From: Jon Puplett [REDACTED]
Sent: 20 December 2021 14:44
To: Simon Davis <Simon.Davis@arun.gov.uk>
Subject: RE: P/159/21/PL 253-255 Inglenook Hotel Pagham Road Pagham PO21 3QB

From: Simon Davis <Simon.Davis@arun.gov.uk>
Sent: 15 December 2021 15:49
To: Jon Puplett [REDACTED]
Subject: P/159/21/PL 253-255 Inglenook Hotel Pagham Road Pagham PO21 3QB

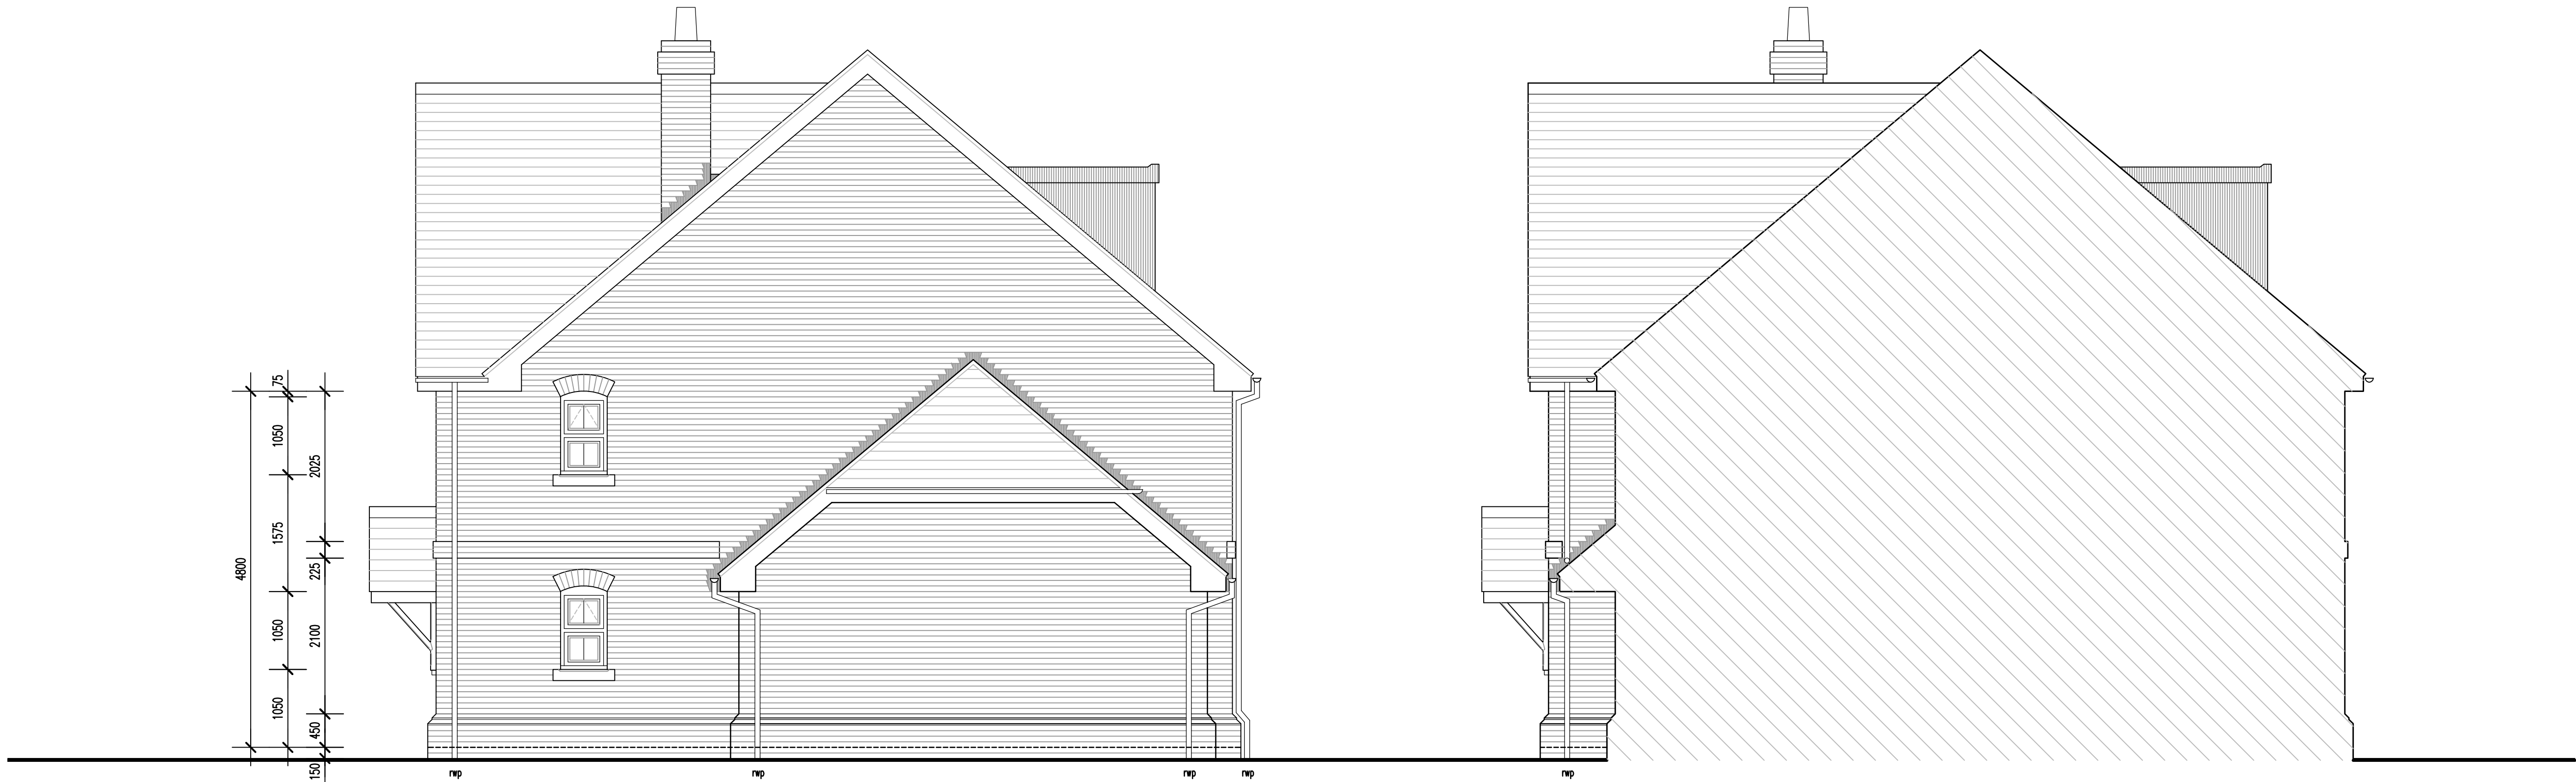
I have been advised by a local resident that the builders are at roof level on plots 8 & 9. I have just now compared the approved and proposed plans for these plots (and for 5 & 6) and it appears that these 4 proposed altered dwellings will have a 0.55m higher ridge. Can you confirm this is correct and can you also advise whether the developer is building to the proposed or approved schemes?

The minor material amendment drawings do show an increase in ridge height in comparison to the approved drawings, as you have stated. I am advised that a minor increase in ridge height was necessary due to structural and technical requirements. The developer / architect have confirmed that it is the current application drawings which the contractors are building to.
